Item No. **Report of the Head of Planning, Transportation and Regeneration**

Address 1 ADELPHI CRESCENT HAYES

Development: Erection of a two storey, 2 bed dwelling with associated parking and amenity space

LBH Ref Nos: **75616/APP/2020/2866**

Figure 1
Open gap between 1 Adelphi Crescent and 3 Adelphi Crescent

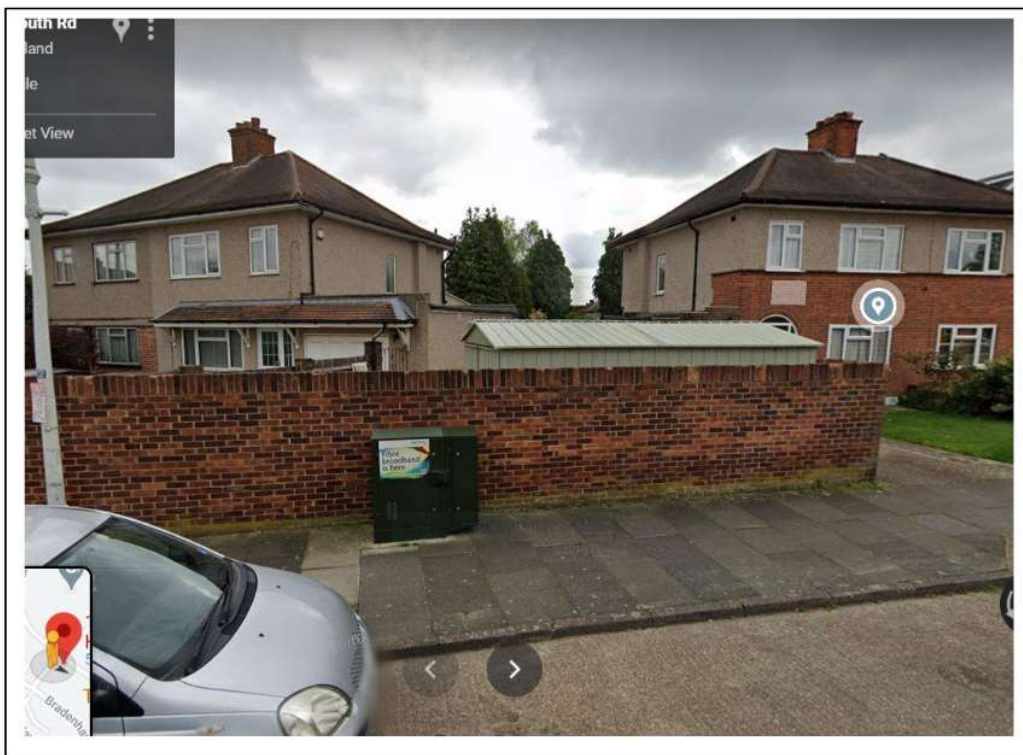
The proposal by reason of its siting in this open prominent position, size, scale, bulk and proximity to the side boundary would result in the loss of an important gap characteristic to the area, resulting in a cramped appearance. The proposal would therefore represent an overdevelopment of the site to the detriment of the character, appearance and visual amenities of the area and to this existing open area of the street scene. Therefore the proposal is contrary to Policy BE1 of the Hillingdon Local Plan: Part One - Strategic Policies (November 2012), Policies DMHB 11 and DMHB 12 of the Hillingdon Local Plan: Part Two - Development Management Policies (January 2020) and Policies 3.5 and 7.4 of the London Plan (2016).

The application site, together with other corner properties in the vicinity are defined by large open spaces to the side of the existing dwellings. It is considered that this open space character gives several properties in the immediate locality, including the application dwelling, the appearance of significant spaciousness within their plots and makes a positive visual contribution to the appearance of the street scene. The open space character and visual gaps also help to clearly define the semi-detached and end terraced contexts of several junction/corner properties in the immediate locality. The corner plot positioning of the application dwelling is such that it is visually prominent on both street scenes. The adjacent properties on Adelphi Crescent have an established and uniform front building line and the front gardens and the side garden area of the application property results in a sense of spaciousness not only at the road junction but along the road. This is mirrored on the opposite side of the road at all 4 corner properties with Weymouth Road and Adelphi Crescent. The proposed dwelling, given its corner plot would appear to largely fill this spacious corner plot with the single storey front projection breaching the return building line. Furthermore, the dwelling is sited right on the boundary with the adjoining property at No. 3 Adelphi Crescent, resulting in a cramped form of development.

Figure 6

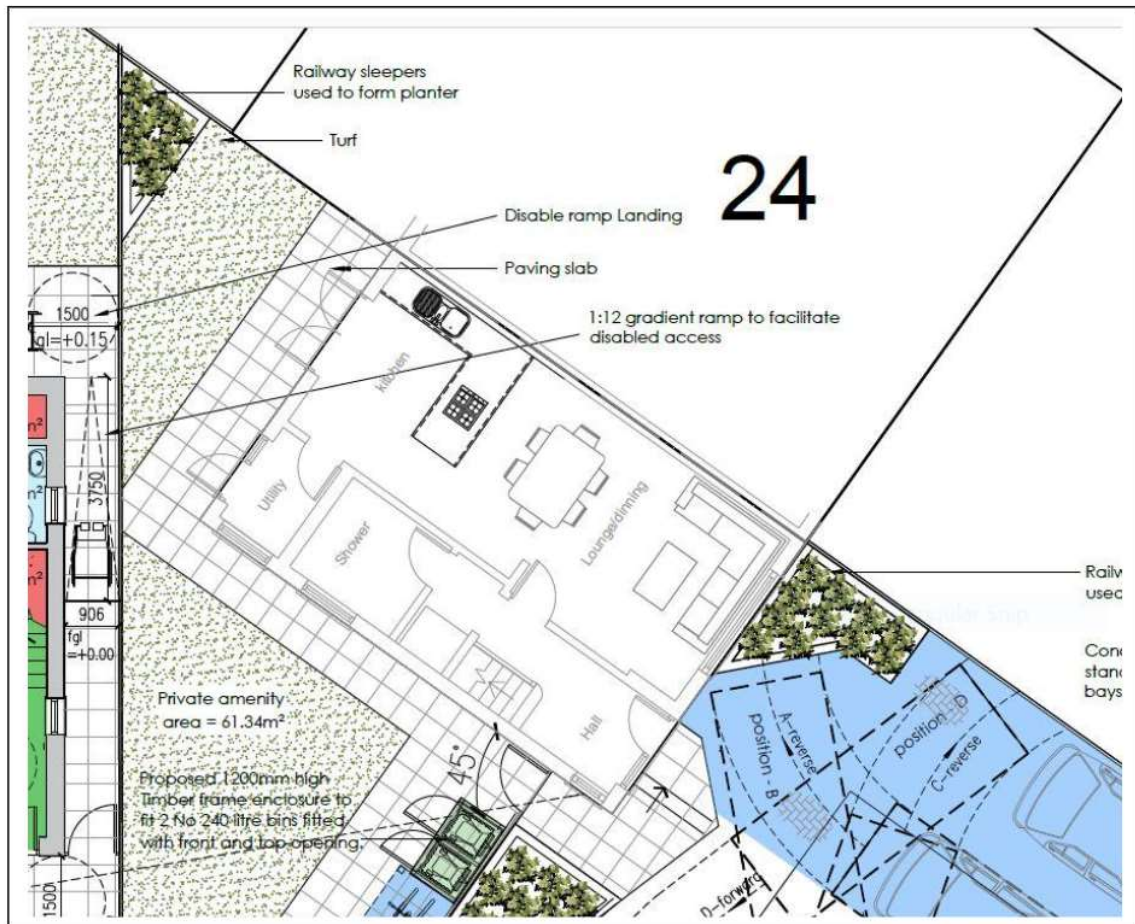
The proposed dwelling, by reason of its siting, size, scale, bulk and proximity, would be detrimental to the amenities of the adjoining occupier at 1 Adelphi Crescent by reason of overdominance, overshadowing, loss of light, visual intrusion and loss of outlook. Therefore the proposal would be contrary to Policy DMHB 11 of the Hillingdon Local Plan: Part Two - Development Management Policies (January 2020).

The separation distance between the two storey elements of the host dwelling and proposed dwelling is just 5.6m. Given the proximity and orientation of the proposed dwelling, the outlook from rear facing windows and the garden to the rear would be dominated by the proposed dwelling resulting in an unacceptable loss of light and outlook to the occupants of this property. Thus, the proposed dwelling, by reason of its siting, size, scale, bulk and proximity, would be detrimental to the amenities of the adjoining occupier at 1 Adelphi Crescent by reason of overdominance, overshadowing, loss of light, visual intrusion and loss of outlook. Therefore the proposal would be contrary to Policy DMHB 11 of the Hillingdon Local Plan: Part Two - Development Management Policies (January 2020).

Figure 7

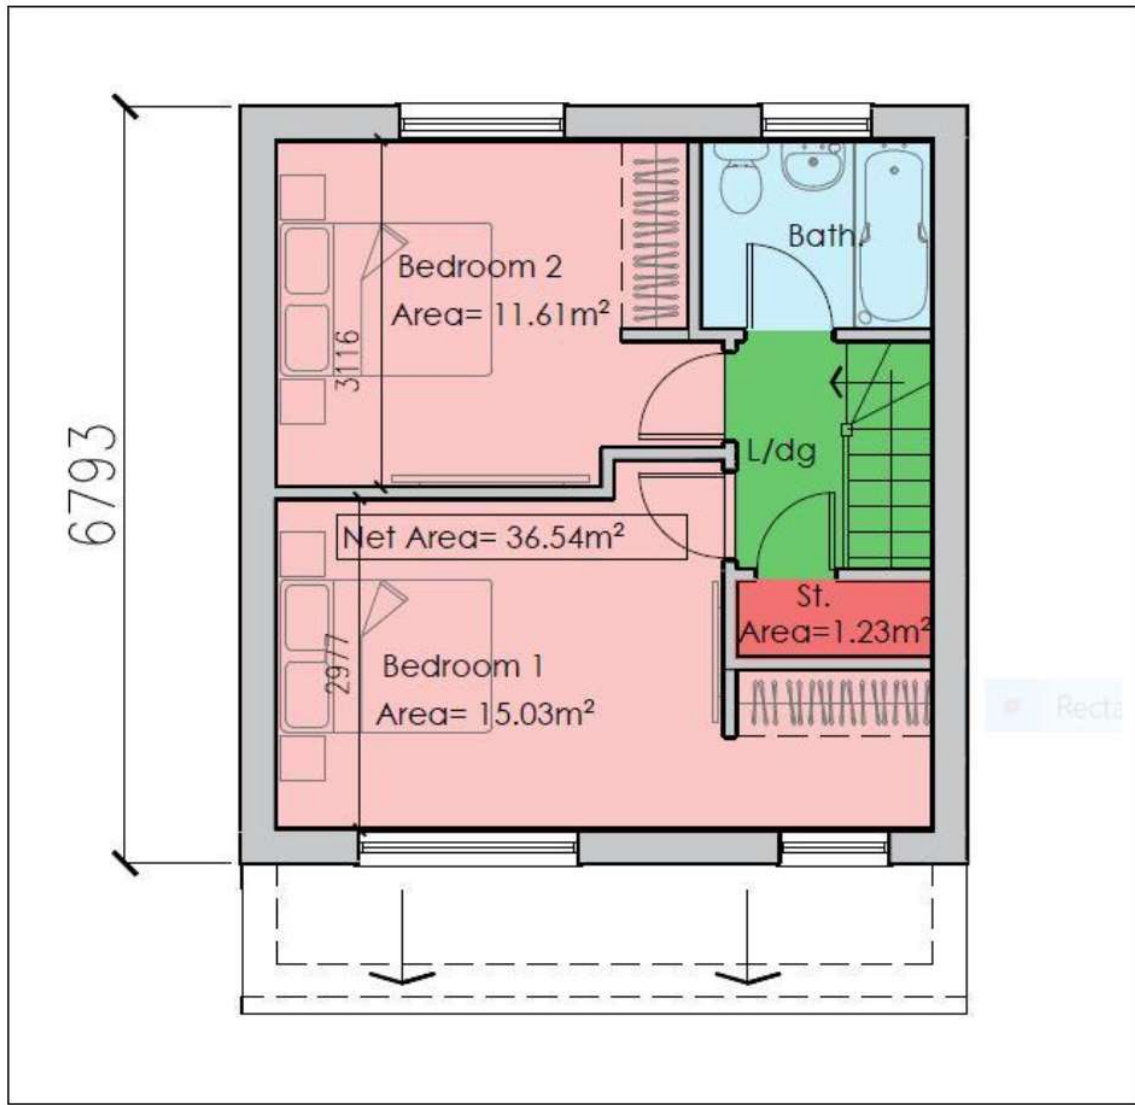
The proposal would provide a double bedrooms of an unsatisfactory size and quality for the future occupiers of the proposed dwelling and would therefore give rise to a substandard form of living accommodation to the detriment of the amenity of future occupiers. The proposal is thus contrary to Policy DMHB 16 of the Hillingdon Local Plan: Part Two - Development Management Policies (2020), Policy 3.5 and Table 3.3 of the London Plan (2016), the Housing Standards Minor Alterations to The London Plan (March 2016), the Mayor of London's adopted Supplementary Planning Guidance - Housing (March 2016) and the Technical Housing Standards - Nationally Described Space Standard (March 2015).

Figure 8
Wheel chair access to property

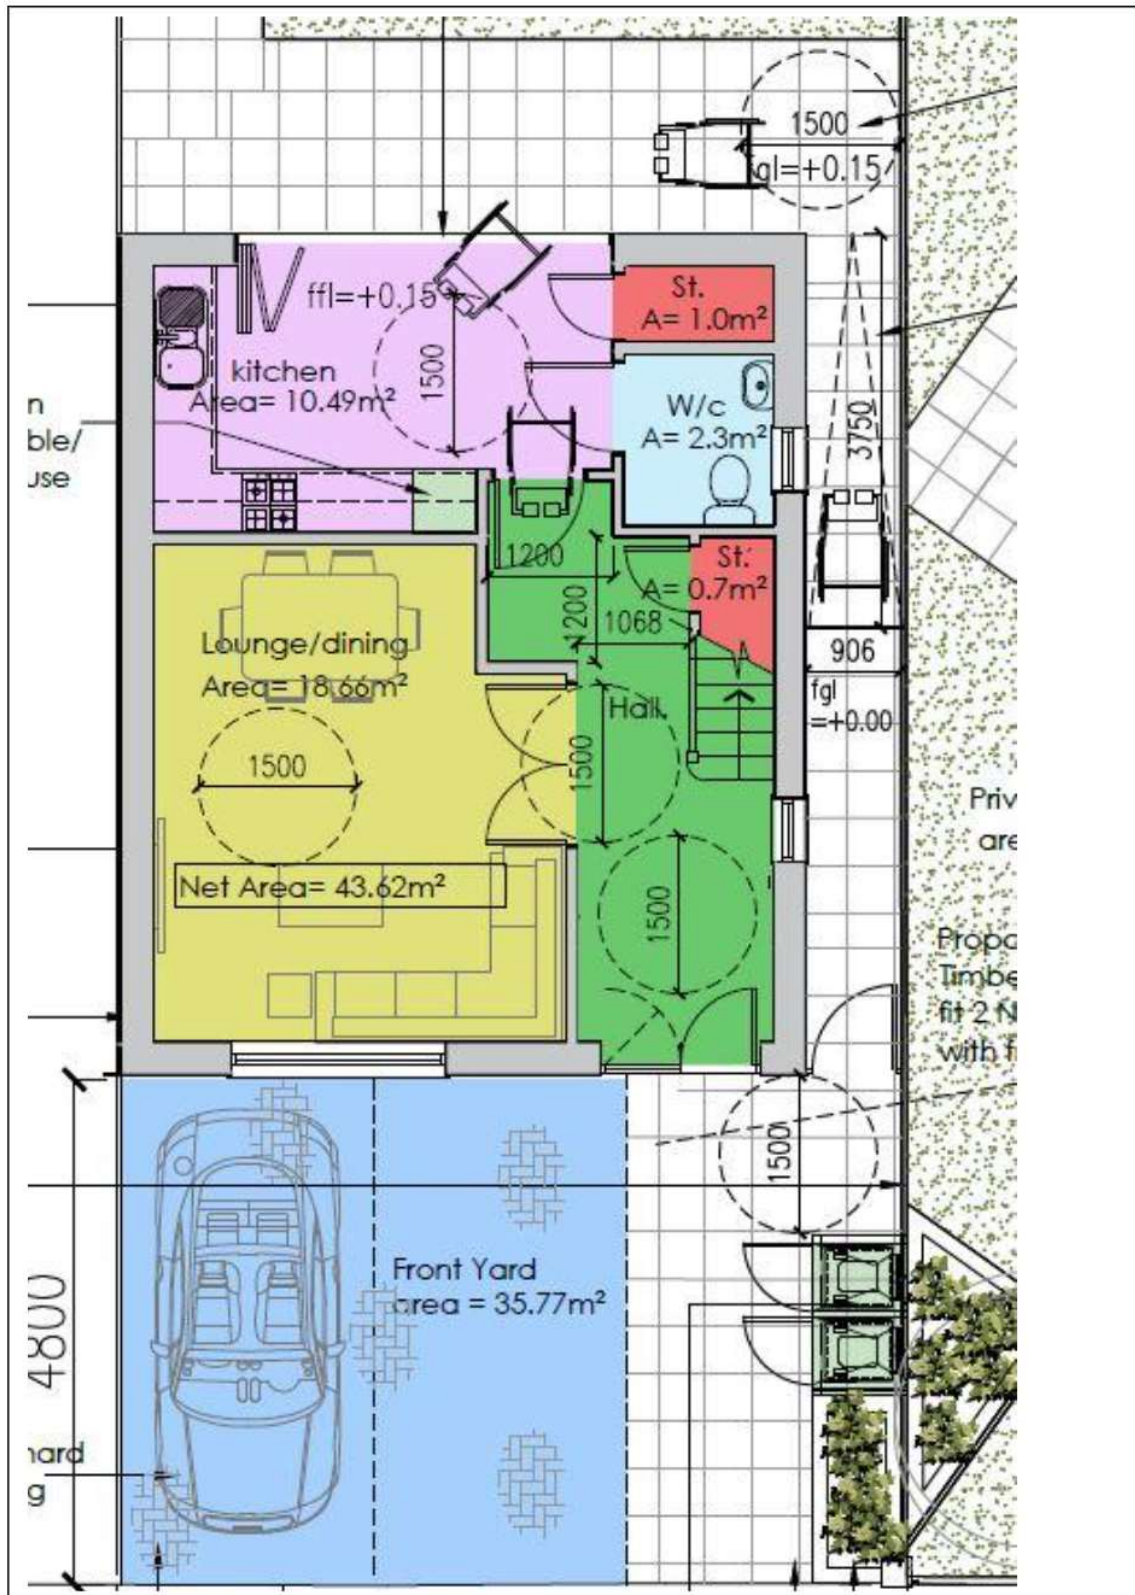
The proposed dwelling, by reason of its size and design would be inaccessible to wheelchair users contrary to policies 3.8 and 7.2 of the London Plan (2016), the Mayor of London's adopted Supplementary Planning Guidance - Housing (March 2016) and the Council's adopted Supplementary Planning Document HDAS: Accessible Hillingdon.

This development application has been assessed against the requirements of London Plan policy 3.8 (c). The floor plans as submitted fail to demonstrate compliance with the above Policy requirements as follows: 1. The porch as shown on plan achieves an inadequate distance of circa 750mm between the swing of the outer door and the inner porch door. This should be increased to a distance of no less than 1500mm in accordance with Diagram 23 as set out in Approved Document M to the Building Regulations 2010 (2015 edition). 2. The hallway width falls below the minimum standard required, particularly on the approach to and into the proposed kitchen. The hallway should be no less than 1200mm wide on the approach into the kitchen. Conclusion: Unacceptable.

Figure 9

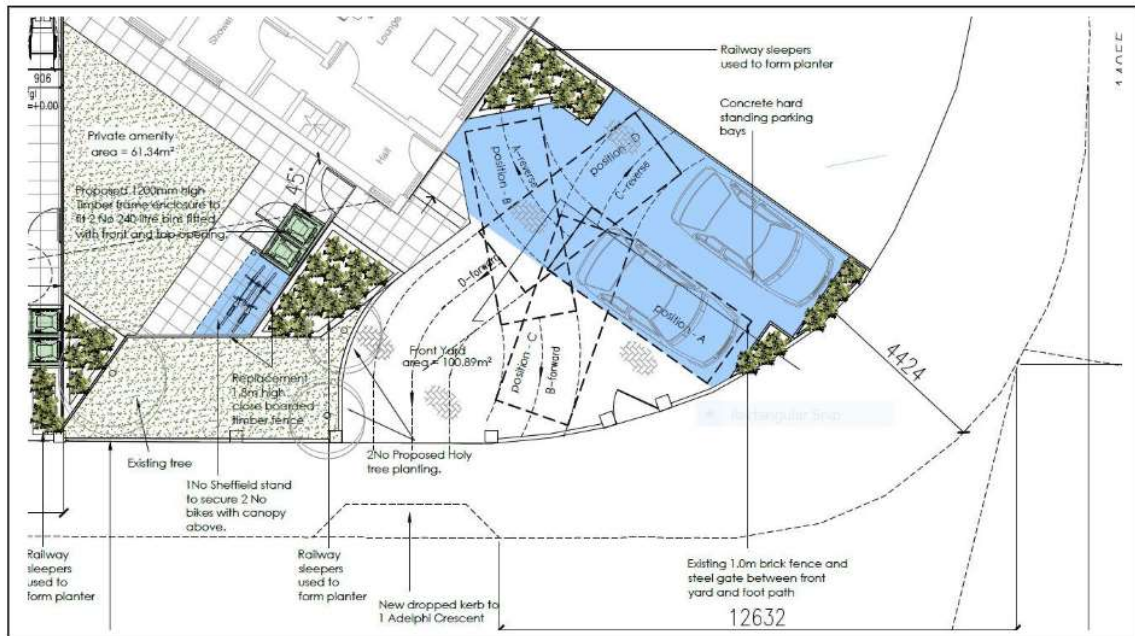
The proposed development would result in the creation of an excessive area of hardstanding at the front of the original dwelling at 1 Adelphi Crescent and the proposed dwelling with a consequent reduction in the overall provision of front garden area/amenity space and soft landscaping. The proposal is therefore detrimental to the visual amenity of the street scene and the wider area contrary to Policy BE1 of the Hillingdon Local Plan: Part One - Strategic Policies (November 2012) and Policies DMHB 11 and DMHB 14 of the Hillingdon Local Plan: Part Two - Development Management Policies.

The proposal would necessitate the introduction of a long driveway to serve the 2 proposed parking spaces on the frontage of Number 1 Adelphi Crescent. The revised plans do include some soft landscaping, however, the frontage would still be dominated by hardstanding which would detract from the character and appearance of the area in conflict with Policy DMHB 11 and DMHB 14 of the Local Plan - Part Two (2020). .
